Application No: AB/39/21/DOC
Site Address: 19 Maltravers Street Arundel BN18 9AP
Description of works: Approval of details reserved by condition imposed under ref AB/125/20/L relating to Condition Nos 3 - details of junction between elevation of extension & flat roof including materials, 4 - materials & finishes for brick & brick bond, 5 - details of new external door including materials, finish & method of glazing, 6 - materials & finishes for rooflight and 7 - details of internal window including proposed glazing.

OWPC35661

Section A-A

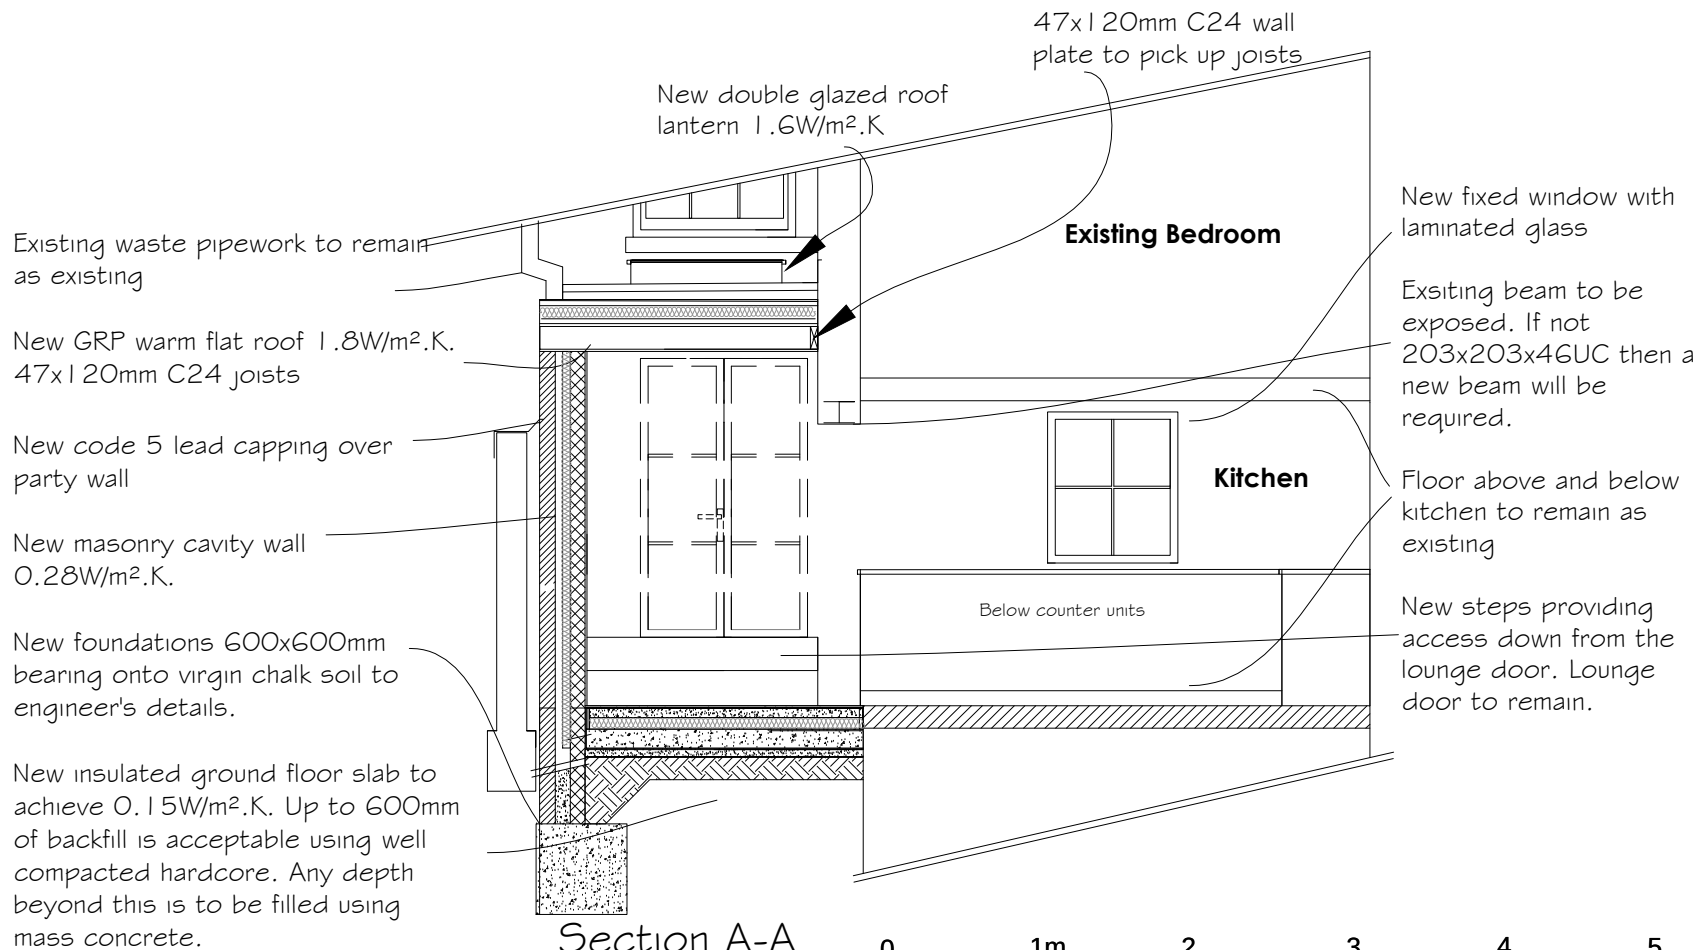
No elevational plans are provided showing the junction between the roof and the external wall of the proposed extension. It would appear from the Agent's correspondence that there will be a painted timber fascia but no details of its depth are provided. Given the age, style and heritage significance of the host building a better solution, rather than a fascia board, would be a small parapet with a stone or reconstituted stone coping. If the Council considers that a timber fascia is suitable then it should be ensured that it is not significantly deeper than the external rainwater gutter.

The use of pvcu rainwater goods as proposed in the agent's correspondence is not appropriate for a Listed Building and cast iron or, given that it will be attached to the new extension, black painted aluminium would be appropriate.
